COLORADO
Division of Water Resources
Department of Natural Resources
Colorado Ground Water Commission

July 10, 2019

RE: Davis Ranch, Filing Nos. 1 and 2
Part of Sec. 3, T14S, R64W, 6th P.M.
Water Division 2, Water District 10
Upper Black Squirrel Creek Designated Basin

FINAL PLAT			
DAVIS RANCH SUBDIVISION FILING NO. 2A			
PROJECT NO.	00100.1	Drawn By: SLG	Date: 006/04/19
		Checked By: DLK	Sheet: 1 of 1

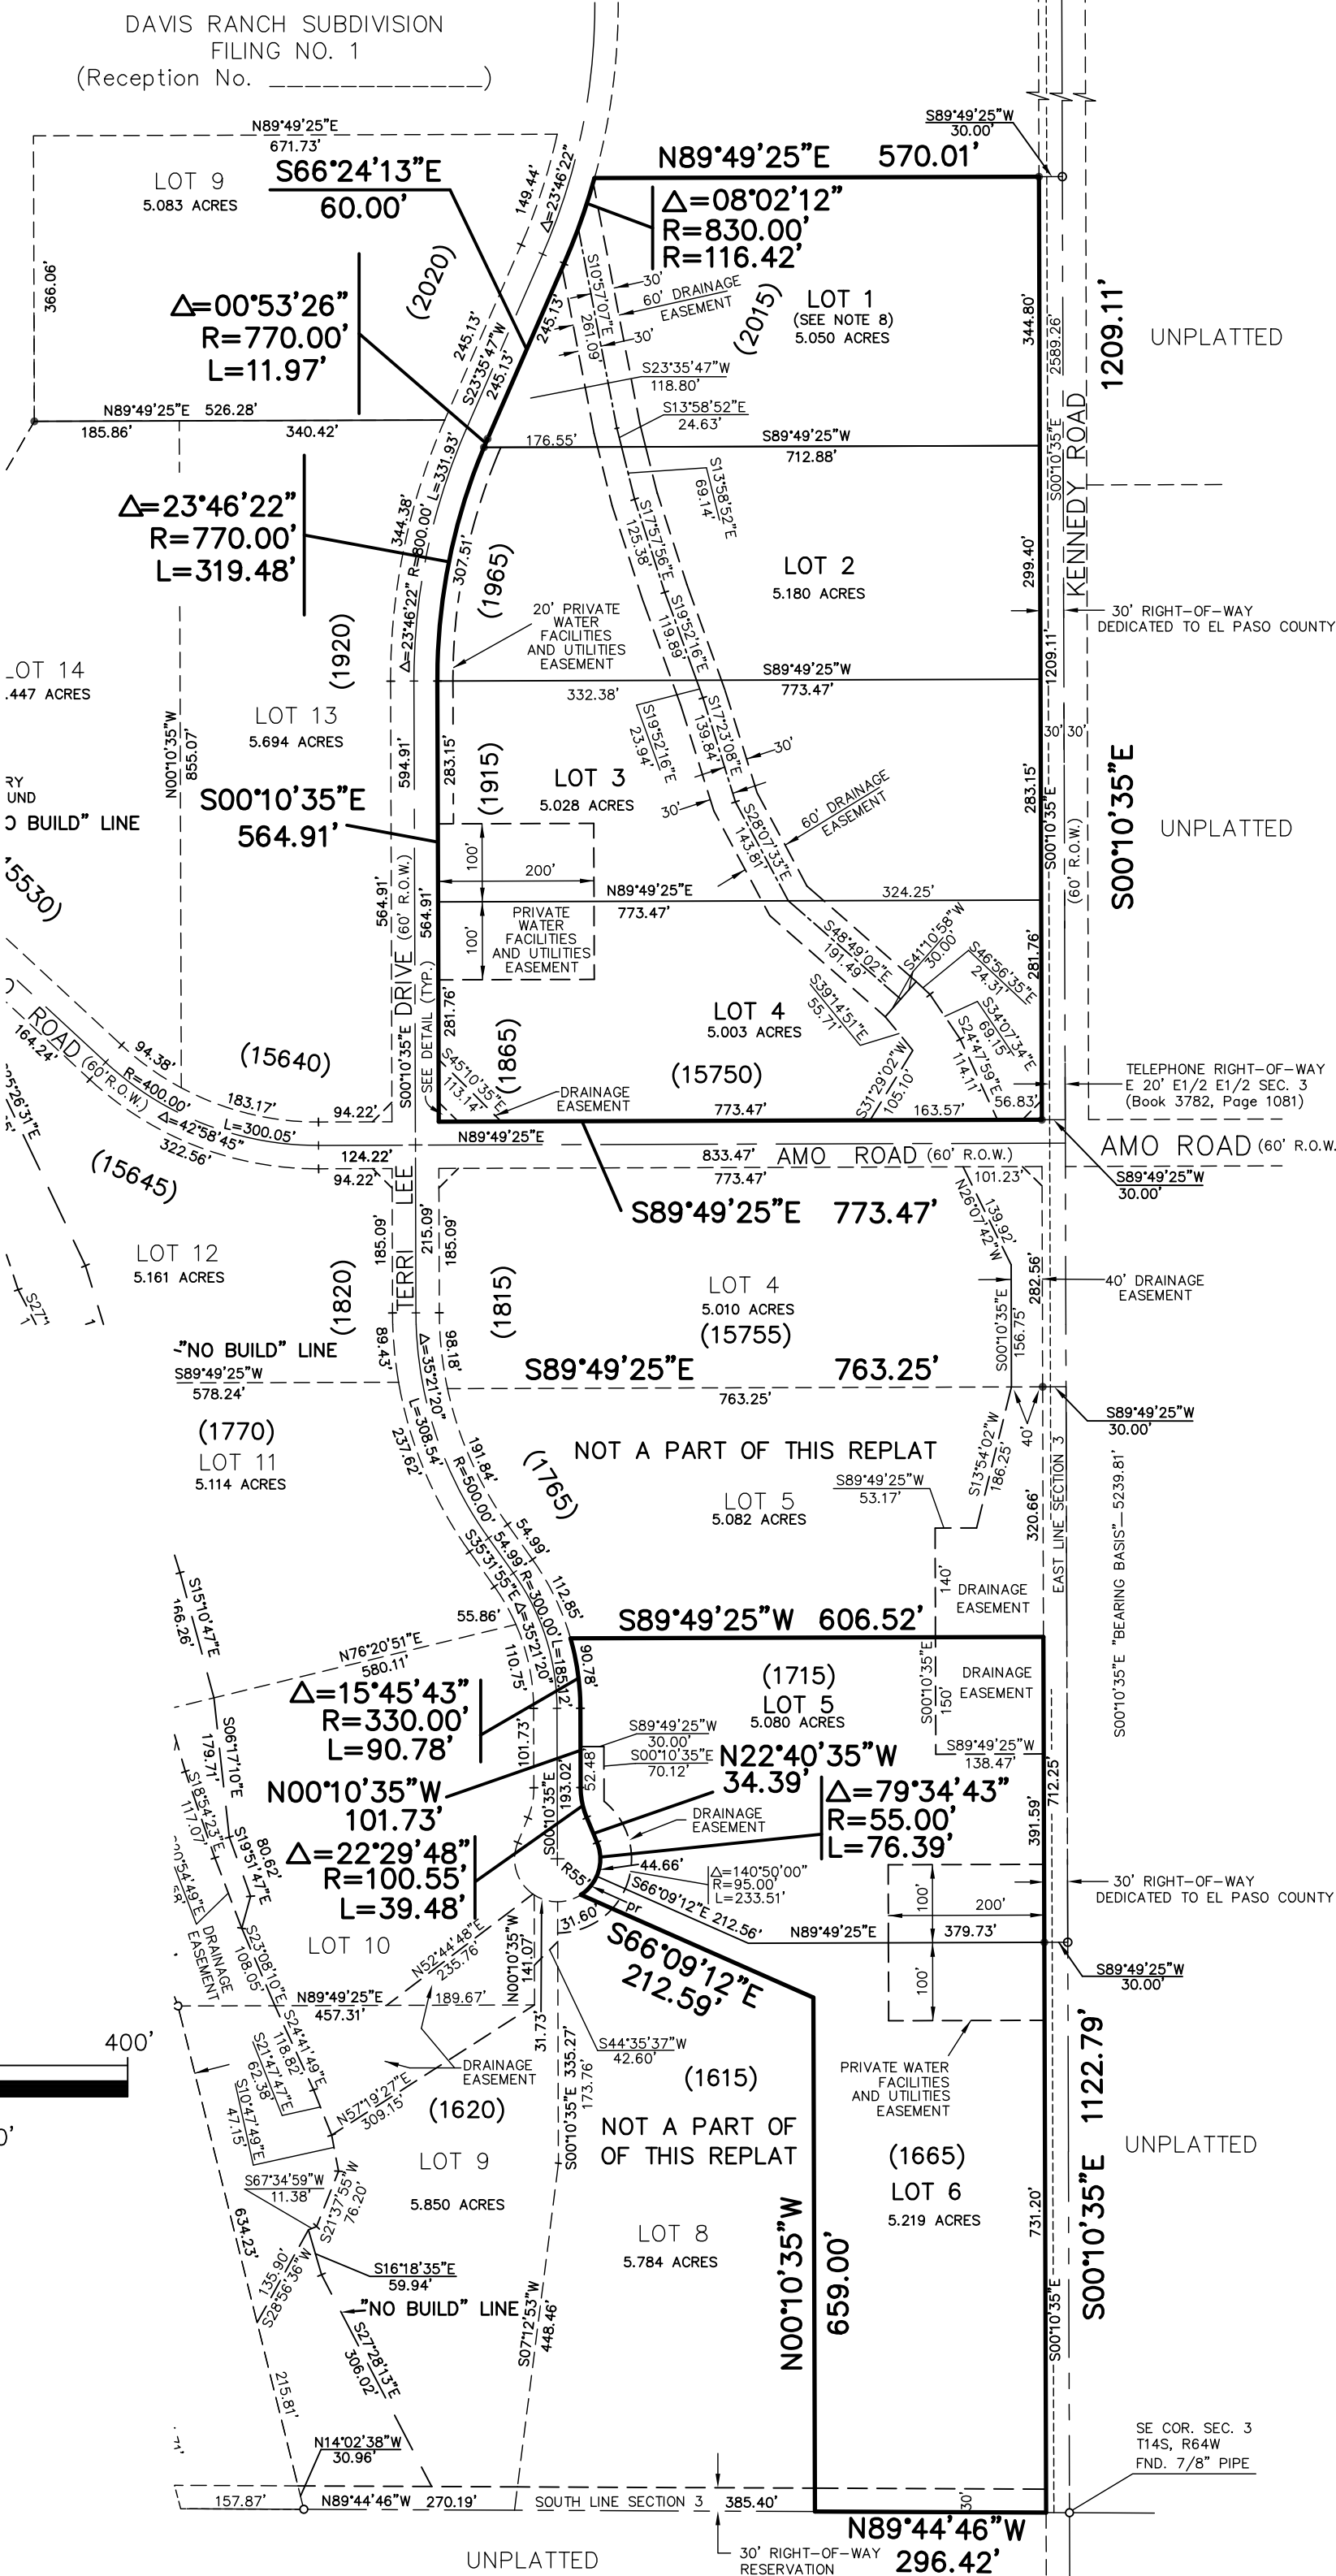
The current submittal proposes that all lots will have individual on-lot use wells, except the following two sets of lots which will each share a well.

1. Lot 8 of Filing 1 and Lots 1, 2, 3 of Filing 2
2. Lots 7 and 8 of Filing 2

1. Well permit no. 83015-F was issued on Lot 2, Filing 2, for use on Lot 8, Filing 1 and Lots 1, 2, 3, Filing 2.
2. Well permit no. 82936-F was issued on Lot 8, Filing 2, for use solely on Lot 8, Filing 2. The use of ground water from this well cannot be used on Lot 7, Filing 2 as currently permitted. In order for this well to be shared with Lot 7, Filing 2, it would have to be pre-permitted.

The developer or owner of Lot 7, Filing 2 should clarify if Lots 7 and 8, Filing 2 will have a shared well water source, or individual on lot wells. If Lots 7 and 8, Filing 2 will have a shared well water source, well permit no. 82936-F must be re-permitted to allow for the use of the well on Lots 7 and 8, Filing 2.
